23/03428/OUT – OS Parcel 7921 South of Huscote Farm and North West of County Boundary Daventry Road, Banbury

I write on behalf of the Banbury Civic Society.

We wish to object in the strongest possible terms to the development of this site for the construction of up to 140,000 sq m of employment floorspace (use class B8 with ancillary offices and facilities), including earthworks to create development platforms and demolition of the existing farmhouse.

Appendix 5.1, Figure 5.2 Zone of Theoretical Visibility 1 - 9m Ht structure
21340 Land East of Junction 11, M40, Banbury

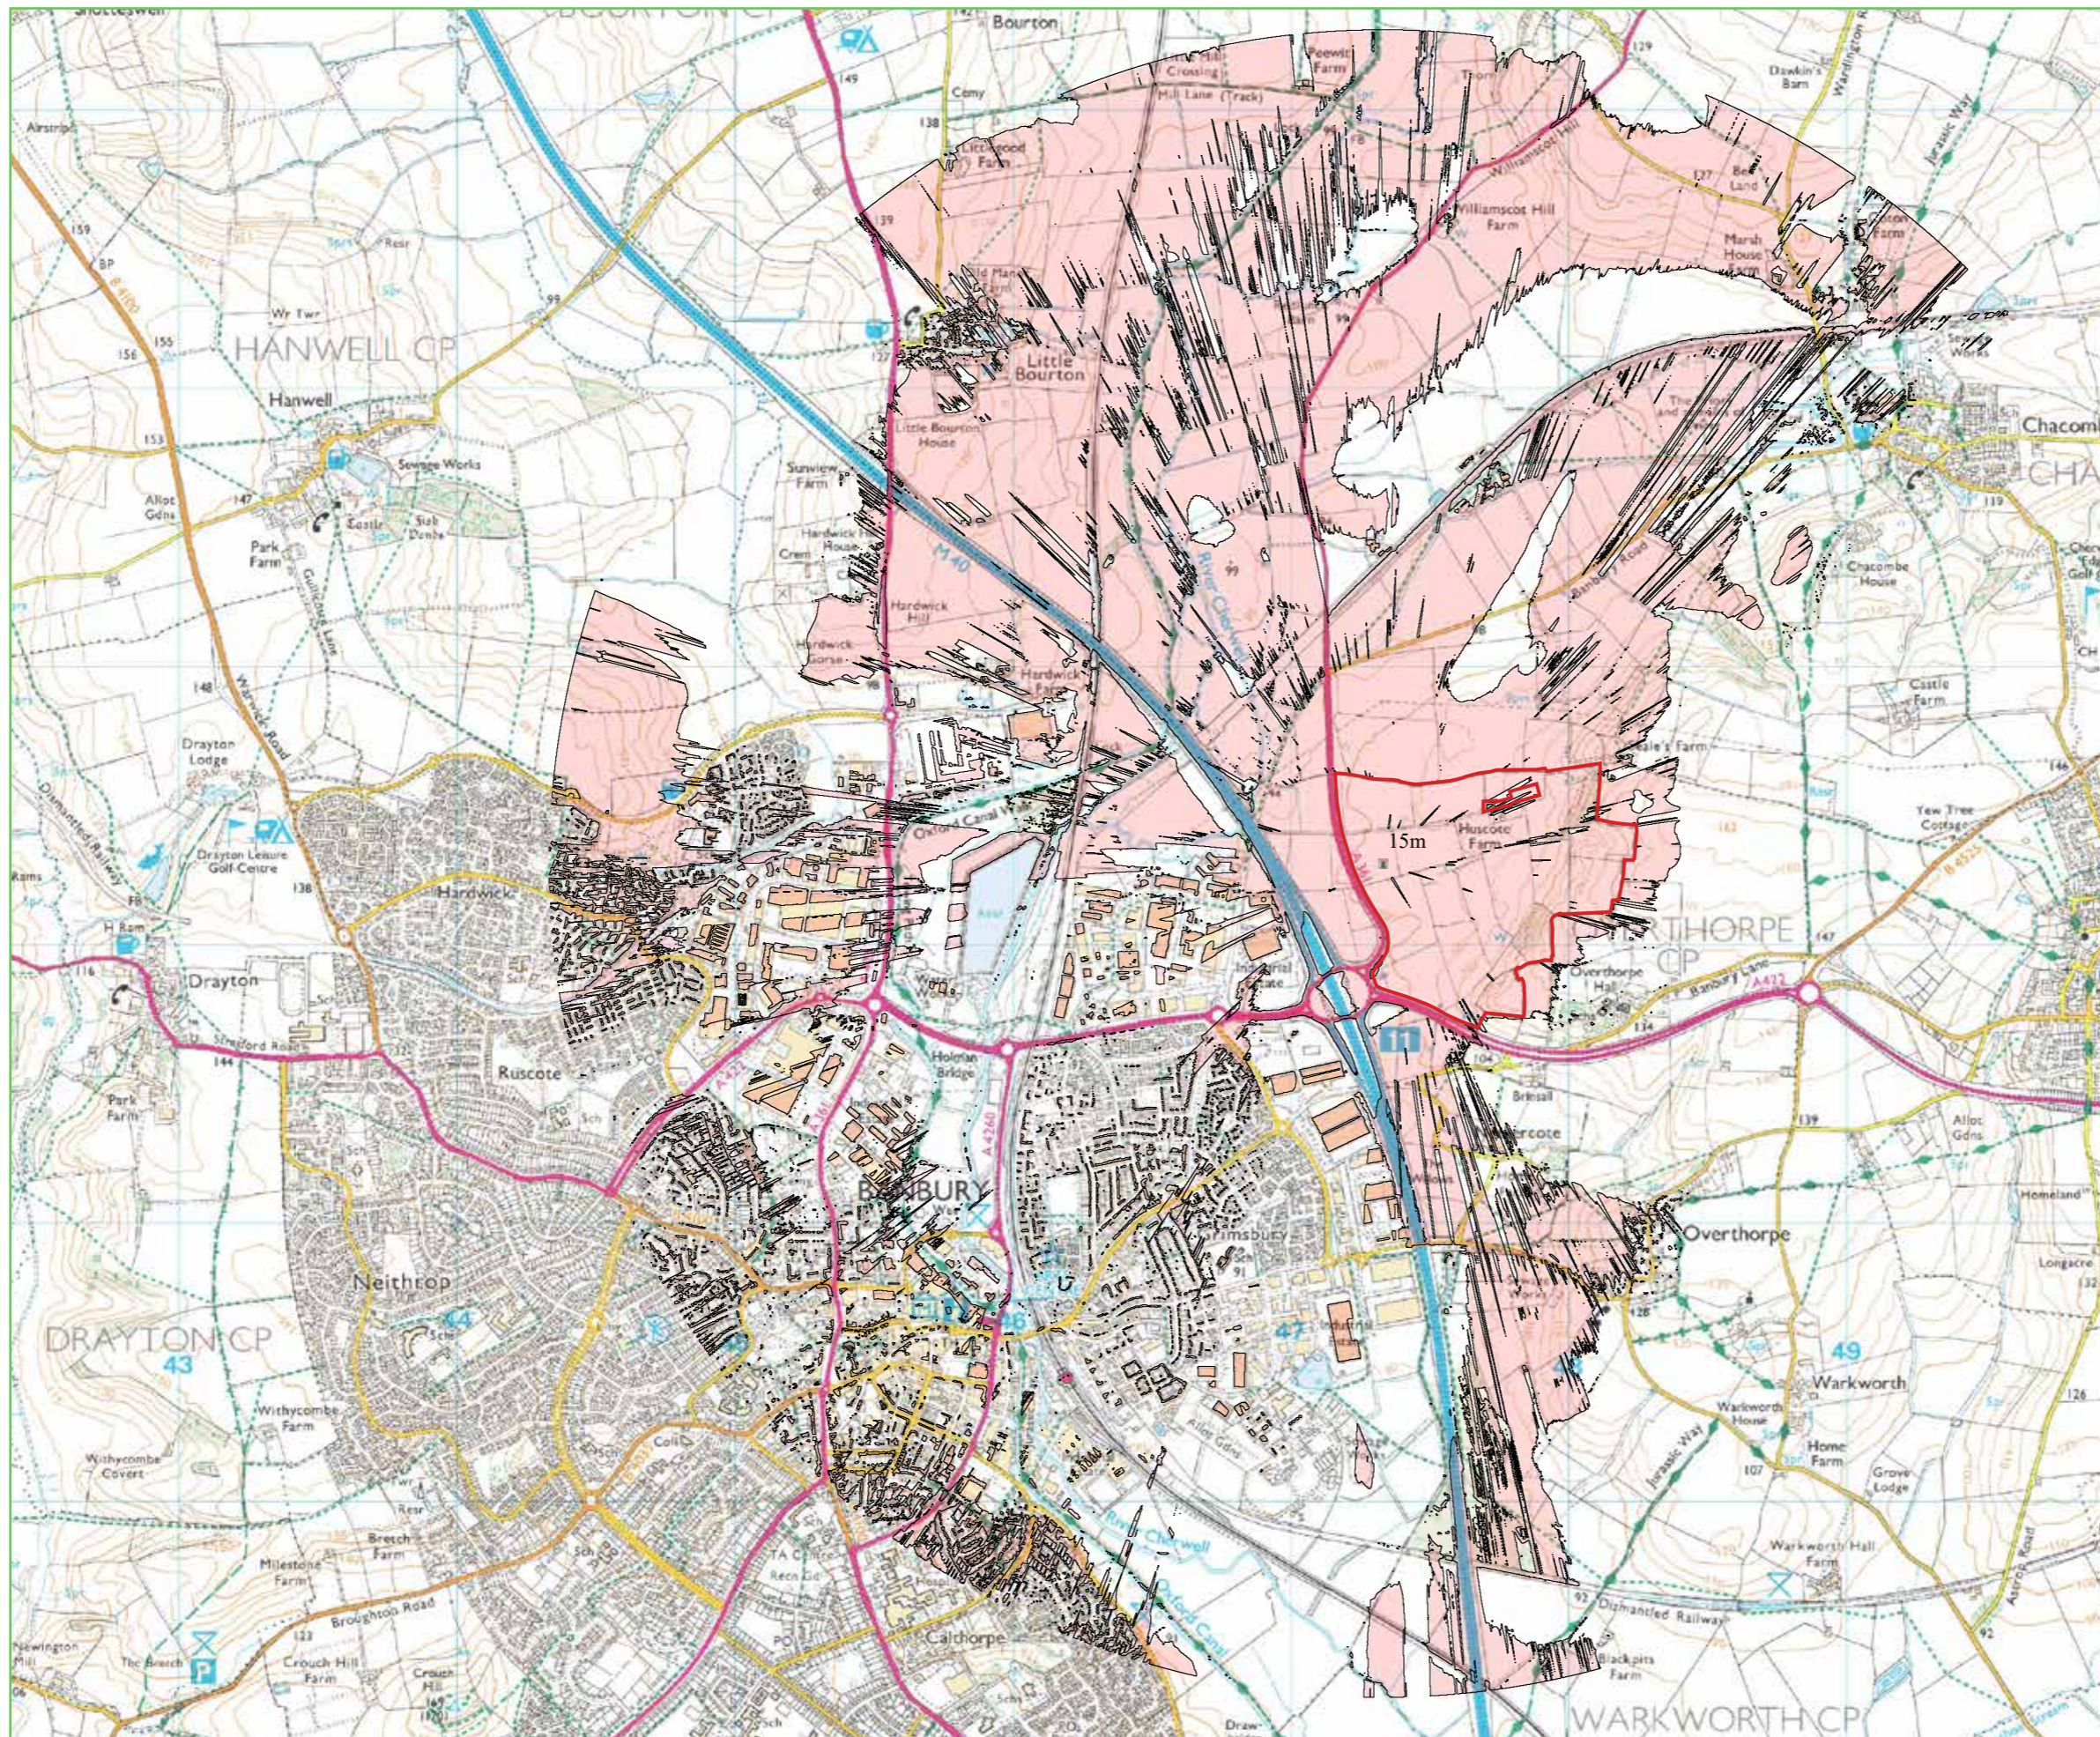
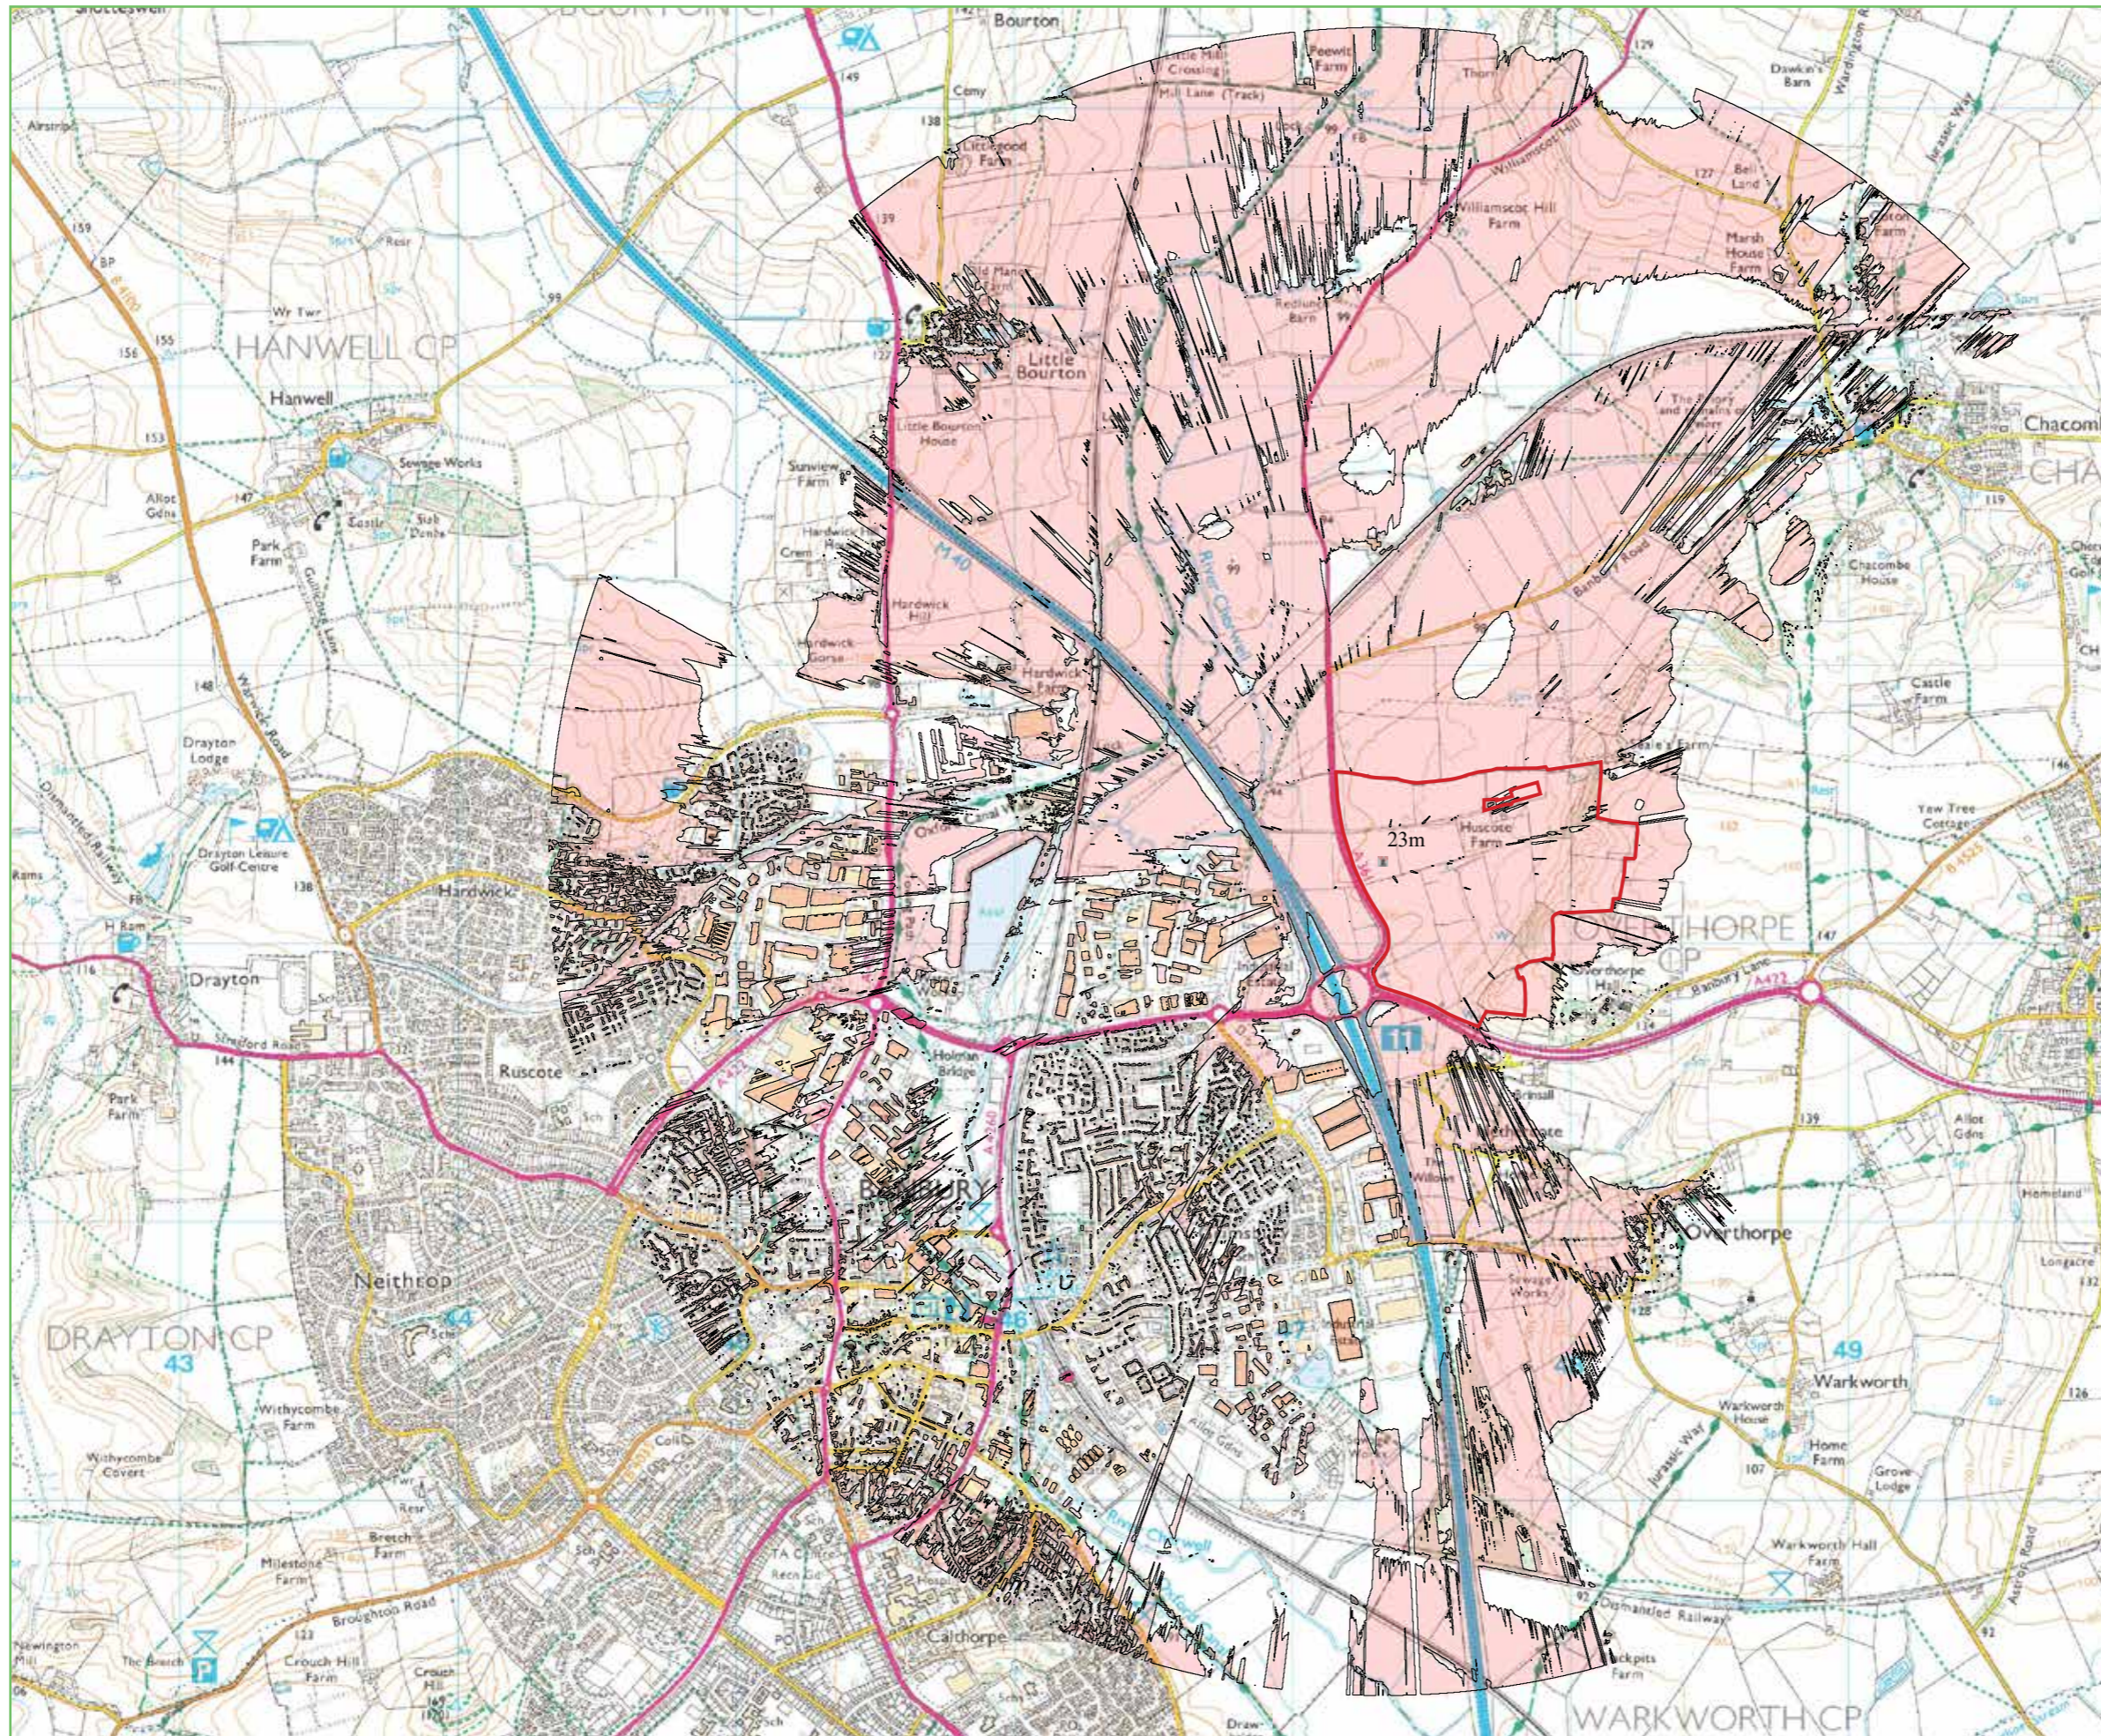
- 2. Zones of Theoretical Visibility (ZTV): *Appendix 5.2 Landscape and Visual* [Impact Assessment] *Methodology*, submitted as part of the ES, states, at paragraph 1.20, that the ZTVs are bareearth only and therefore a 'worst case'. This is not a correct statement. As Figures 5.1 to 5.4 (aka Figs 1 to 4) illustrate, vertical elements have been factored in to the ZTV.
